REQUEST for PARCEL SEGREGATION and BOUNDARY LINE ADJUSTMENTS

SUBJECT: Pierce SEG 06-87

DESCRIPTION: Segregation in Agriculture 20 Zone

TO: Community Development Services  
FROM: Randy Carbary, Planner II *RC*  
DATE: July 25, 2006  
SUBJECT: Pierce SEG-06-87, 17-18-07030-0015

PIERCE PROPERTY

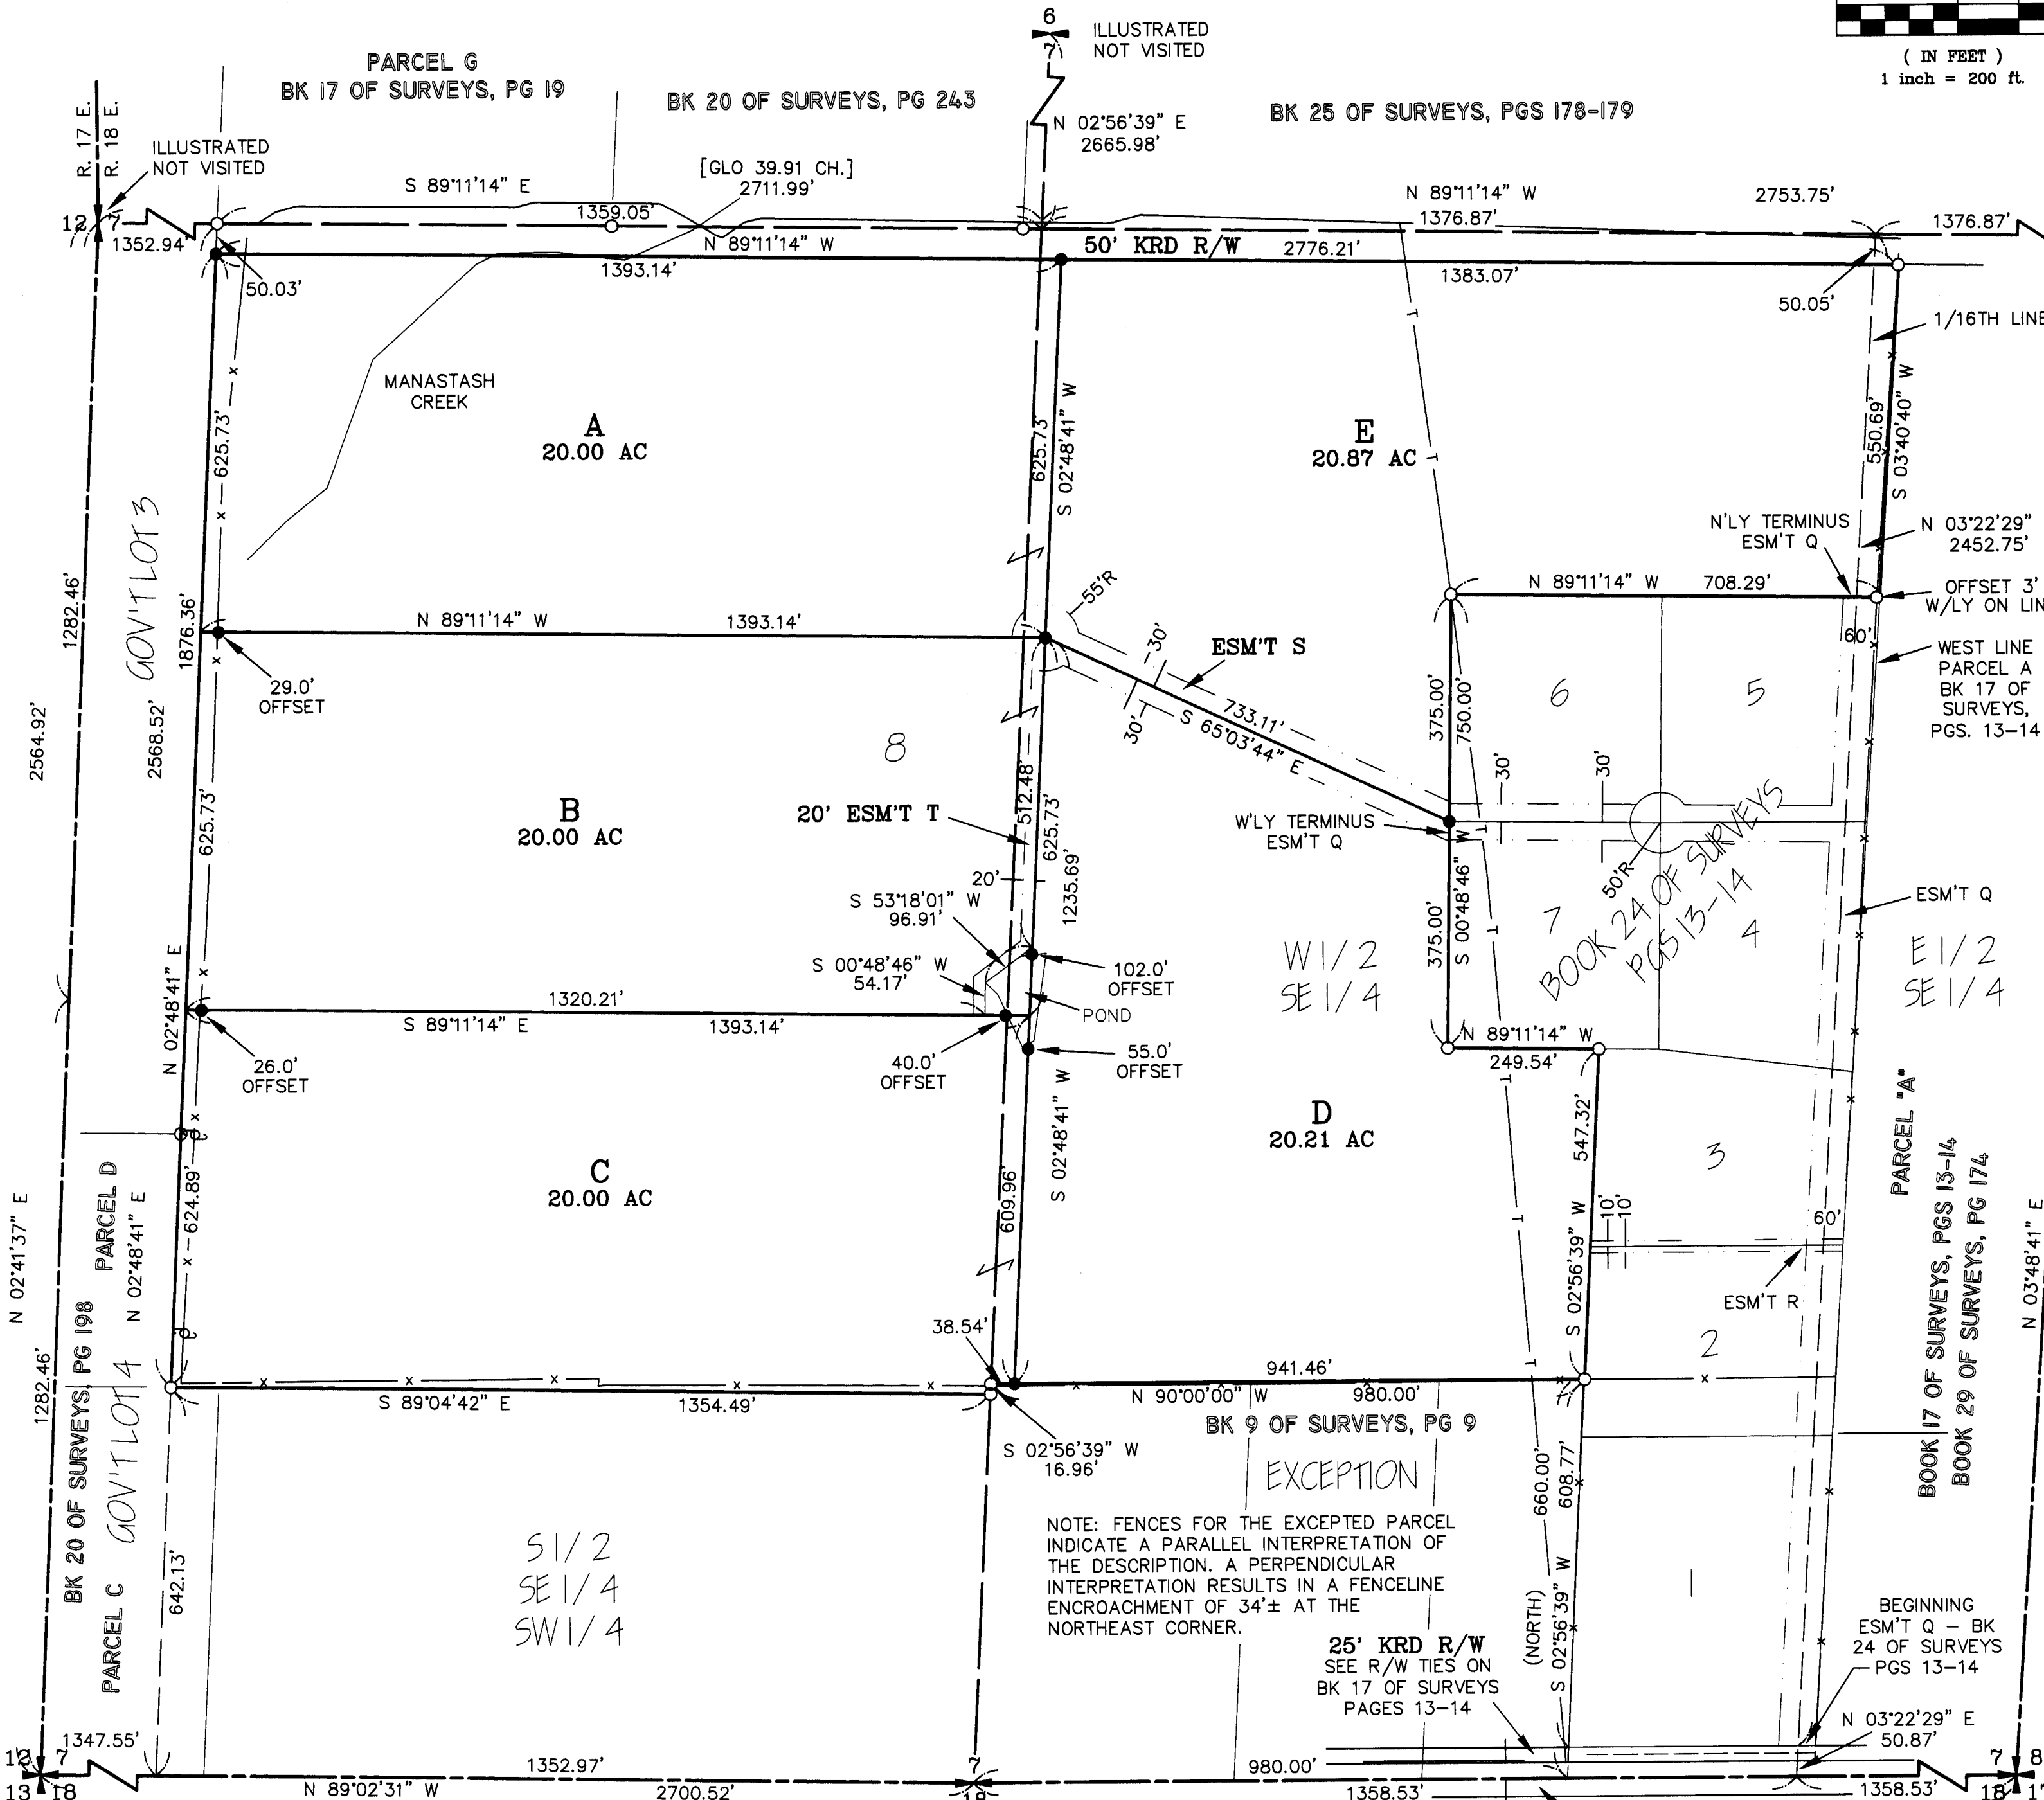
1. Prior to Final Approval the proposed access with appropriate easement(s) shall be shown and shall conform to applicable Kittitas County Road Standards.
